PLANNING AMENDMENT

APPLICANT NAME AND ADDRESS MR & MRS BUTLER THE OLD RANCH LOW ROAD HOLBEACH HURN Telephone:	AGENT NAME AND ADDRESS BRIAN GILHAM WESTFIELD LODGE LOW LANE HOLBEACH Telephone: 01406 424343
SITE ADDRESS DETAILS AS ABOVE	
CURRENT APPLICATION NO: This amendment cannot be considered unless the relevant reference is stated.	H09-0130-24
Building Regulation reference relating to same development (if applicable)

SITE PLAN
1:500

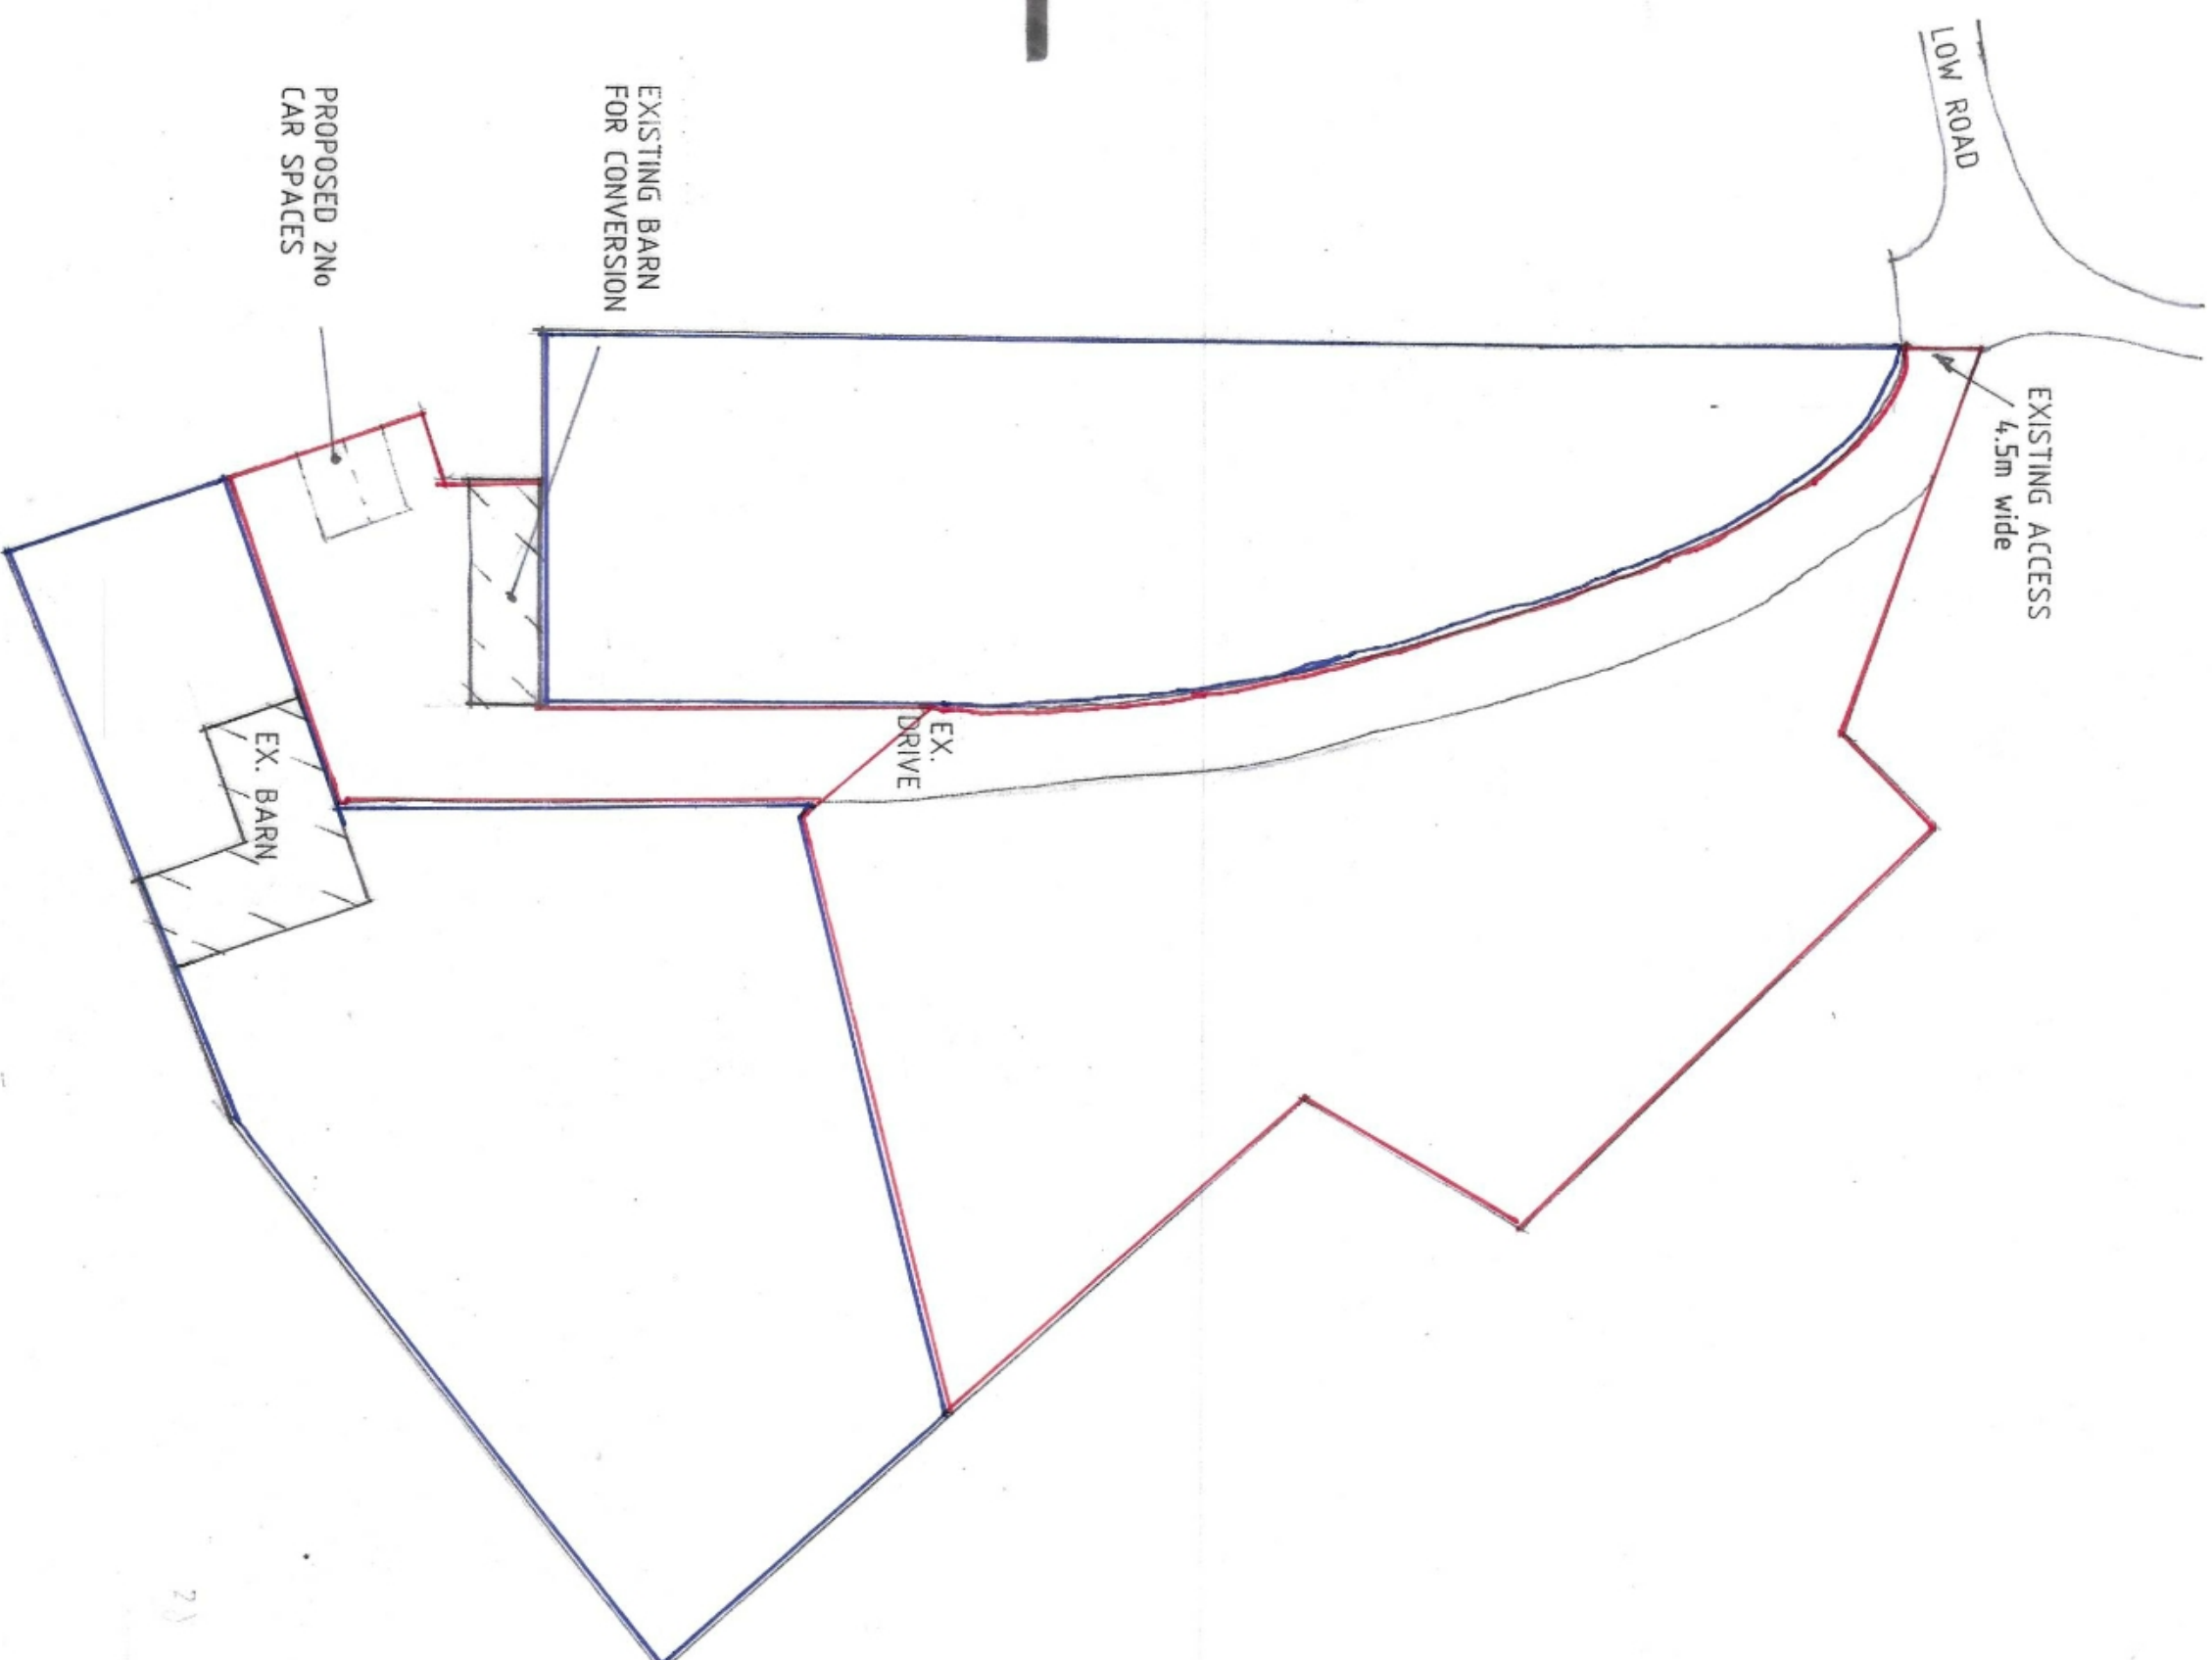
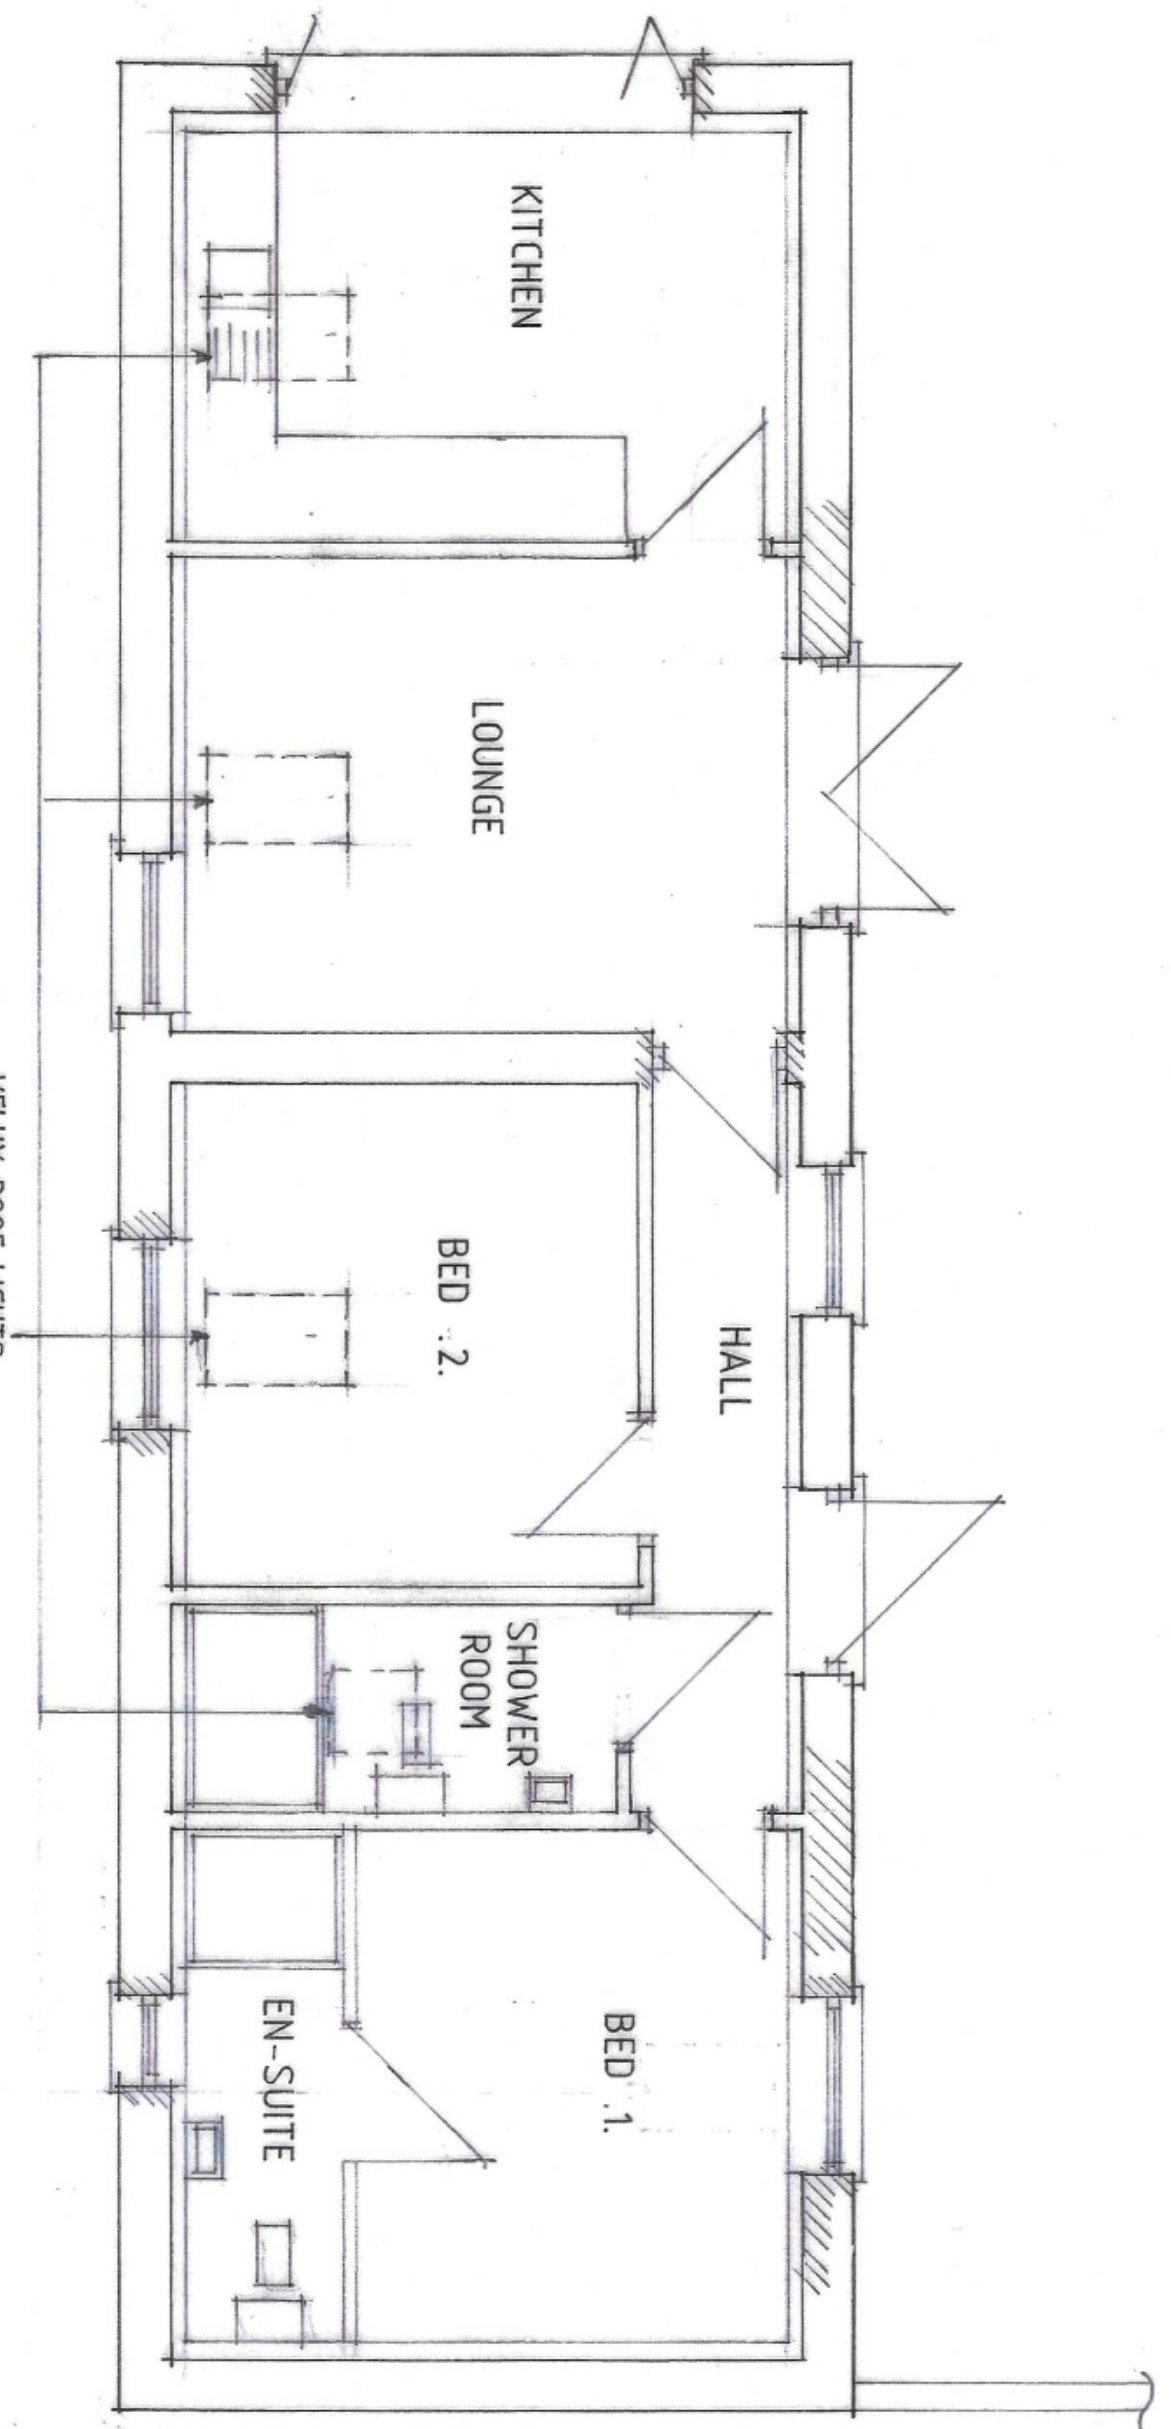
FULL DESCRIPTION OF DEVELOPMENT OF CURRENT APPLICATION THAT THIS AMENDMENT RELATES TO		
State details of amendments proposed. (Give a full detailed list of the changes; and also mark these clearly on the accompanying plans. Only the changes listed here will be considered)	Drawing to show access	
State drawing numbers of the current submission	S024-008/1 S024-008/2	
Has this amendment been requested by the Council? (If so, state Officer dealing with the application)	YES/NO	
Describe any part of the original development which is excluded by virtue of the amendment, and state any alteration to plot numbers		
Has a similar amendment been submitted under Building Regulations? (If so, state Building Control Surveyor dealing with application)	YES/NO
